01 February 2018

**Re: Response to GANSW review of SSD 8372, Smalls Road Public School Development Application.**

1 North East Elevation
2100 1:200

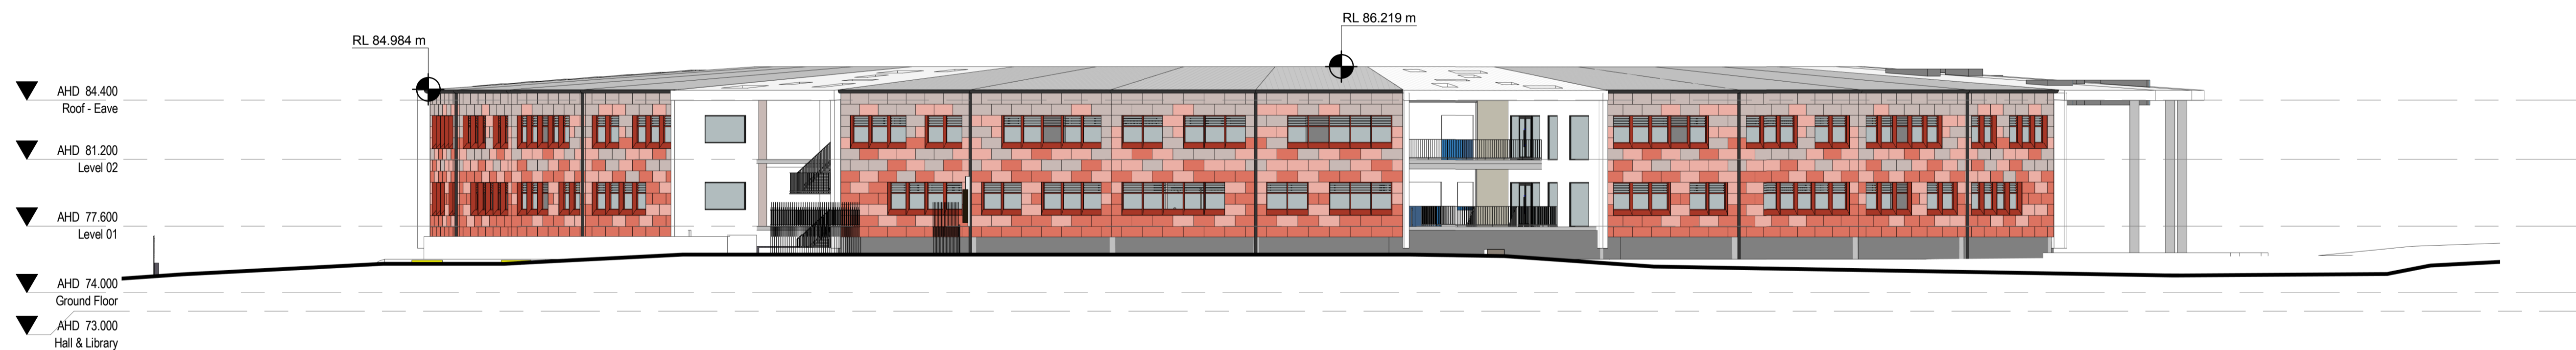
Review the design approach to the building elevations to more appropriately reflect the boldness and playfulness of the plan diagram.	Comments regarding the desire for review of the façade detailing to reflect the playful and bold planning approach are noted. During the detailing and documentation stages of the project we will further develop the cladding and detailing strategies to further pursue the playful nature of the development.
Further development of the courtyard landscape plans to address overshadowing during winter months.	Comments are noted and the landscape design will consider solar access during the winter months through review of dense vegetated areas and appropriate selection of planting species.
Review material and detailing of the façade with a view to establishing an approach that retains the curve, rather than a faceted outcome.	Extensive early research into the buildability and cost impacts of a curved versus a faceted faced were undertaken and review with the Department of Education and technical stakeholders. For a variety of reasons it has been established that a faceted construction is preferred.
